Report of the Head of Development Management and Building Control

Address: 42 SIPSON ROAD WEST DRAYTON

Development: Erection of a single storey rear extension, which would extend beyond the rear wall of the original house by 4.00 metres, for which the maximum height would be 3.00 metres, and for which the height of the eaves would be 3.00 metres

LBH Ref Nos: 79501/APP/2025/1444

PROPOSED GROUND FLOOR PLAN

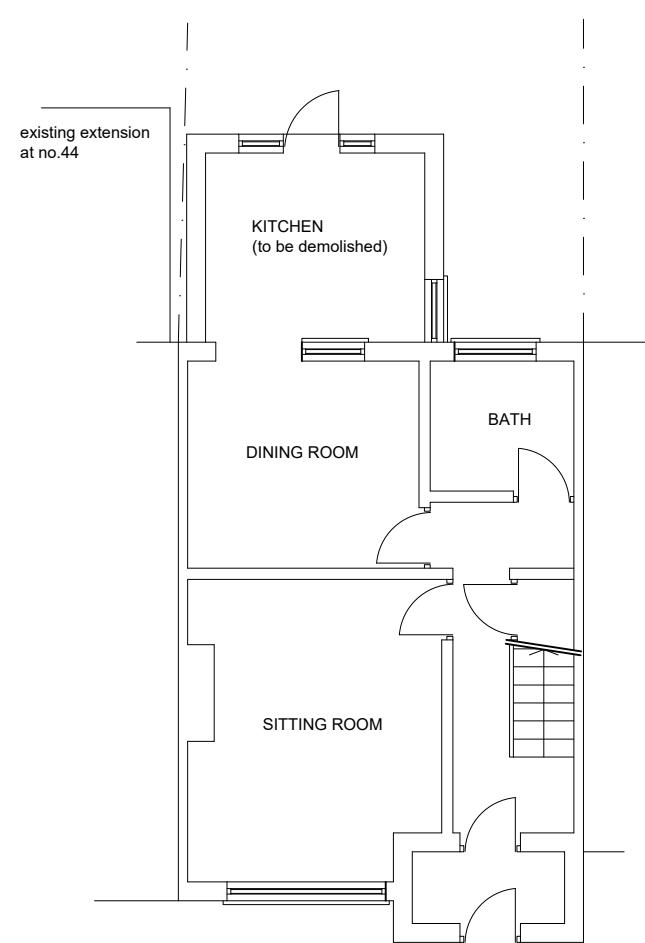
The proposed single storey rear extension would have a depth of 4m with a maximum height of 3.00m and eaves height of 3.00m and would be characterised by a flat roof.

Number 40 Sipson Road adjoins the site to the north west and does not benefit from any extensions. While noted that there is an existing extension at the site, it is set away from the boundary with No.40 by approximately 1.9 metres reducing the impact it has on the occupiers of the property. The proposed development would extend the full length of the rear of site and would be 4m deep and 3m high. Due to its combined height and depth, the extension would cause a significant loss of light and outlook to the habitable ground floor rear windows of No.40, subsequently harming the amenities of the property's occupiers. Whilst the proposed flat roof would meet the Council's recommended height standard, the proposed rear extension would exceed the Council's recommended depth standard set out in Part B of Policy DMHD 1 of the Hillingdon Local Plan: Part Two - Development Management Policies (January 2020).

On balance and for the reasons outlined above, it considered that the proposed development would have a harmful impact on neighbouring amenities of No.40 Sipson Road in terms of loss of light an outlook.

H F M DESIGN Email: info@hfmdesign.co.uk Tel: 079000 85267		
Site: 42 Sipson Road UB7 9DP		
Drawing Title: Proposed Elevations		
Client:	Date: May 2025	Drawn by:
Drawing No.: S/0525/HH3	Scale: 1:100@A3

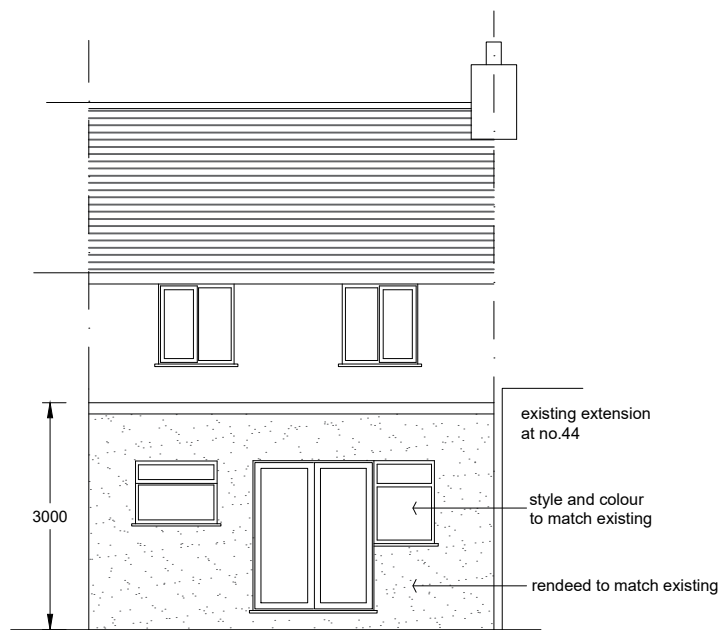
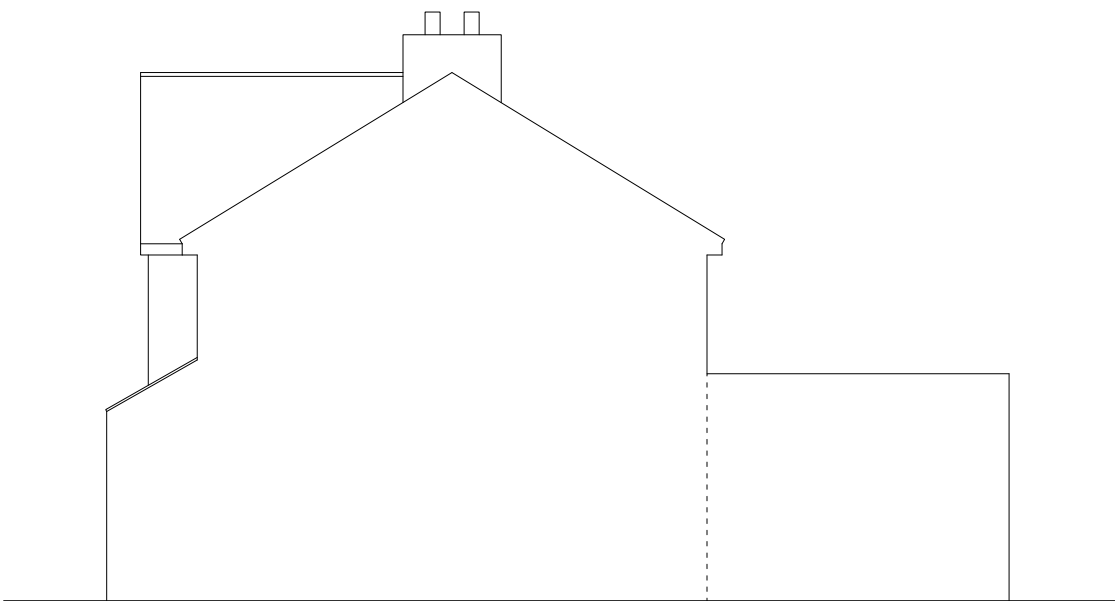
Number 44 Sipson Road has an existing conservatory along the shared boundary which measures approximately 3metres deep, therefore the proposal would extend 1 metre beyond the adjoining extension at no.44. Given this point, the proposed extension is considered to cause minimal impact. In addition, the design considering the moderate height and depth s considered to cause no harmful loss of light, outlook or privacy to the occupiers of No.44.
